Change of use of land to be used in conjunction with 37 St Osmund Road and erection
of 1 No detached timber garage

Land to the East of Paddocks End 37 St. Osmund Road Ferring

FG/68/12 Planning Application Objection :-

PROPOSED SITE PLAN SCALE 1:200

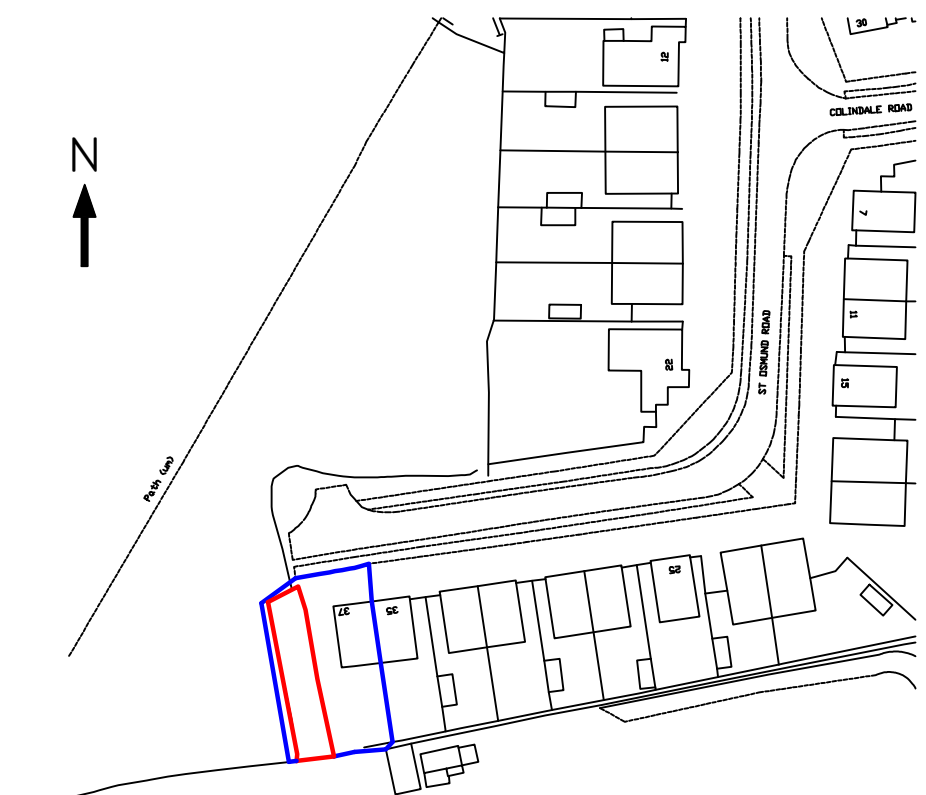
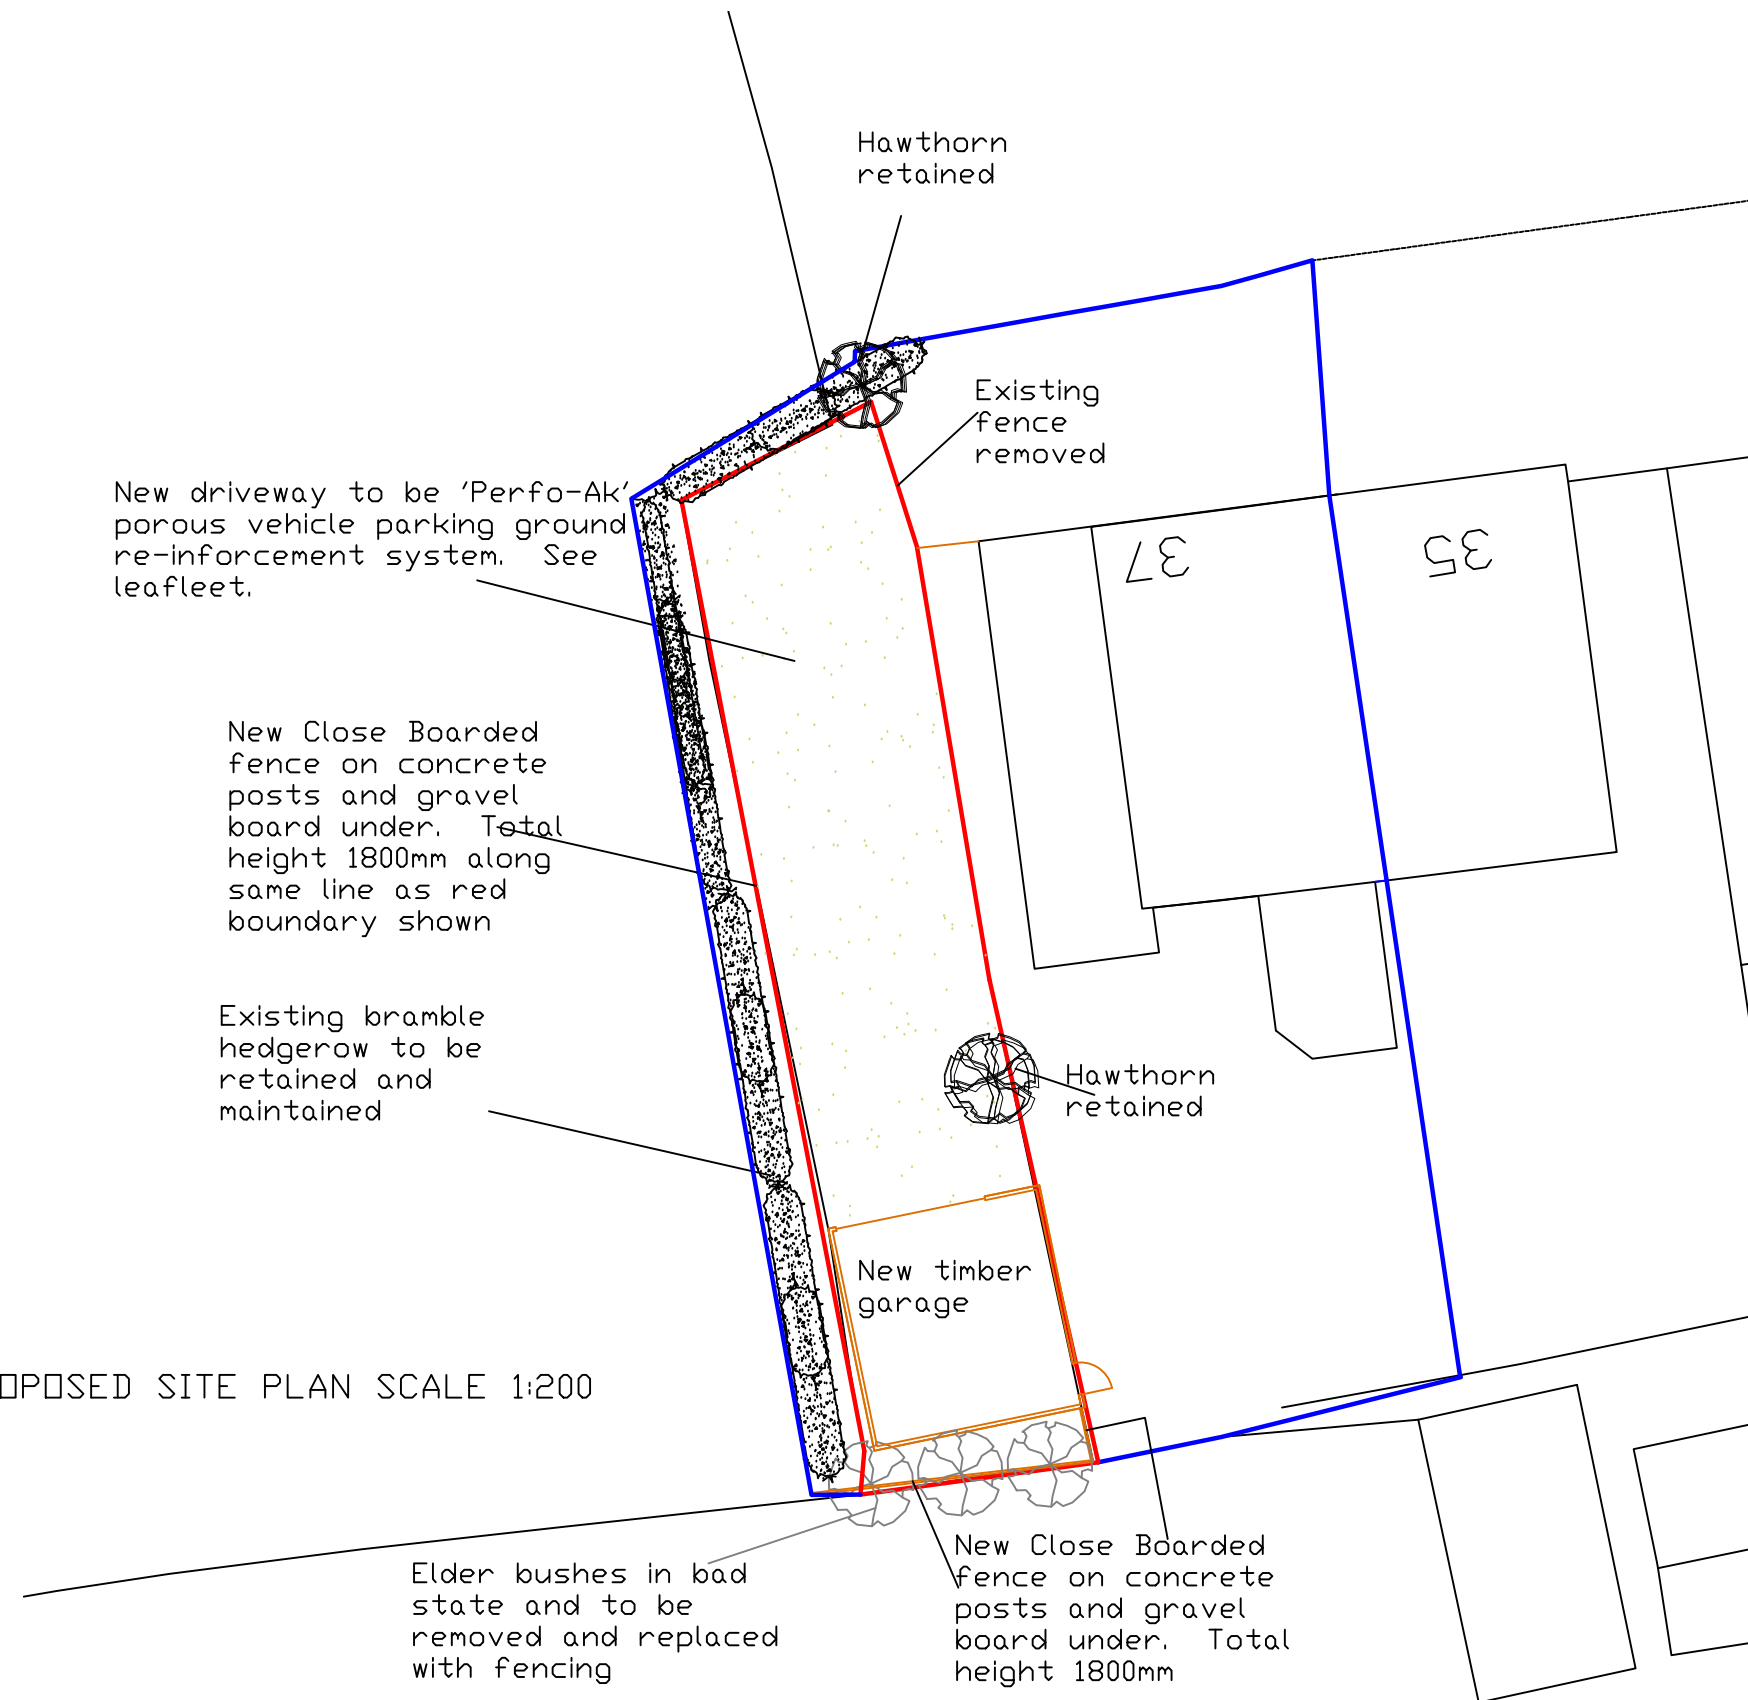
- a. the footpath is not shown on this Planning Application*
- b. evidence is required that this is not part of the Strategic Gap*
- c. the land has a huge drainage problem, is often under water and there is no flood risk assessment attached to the Application*
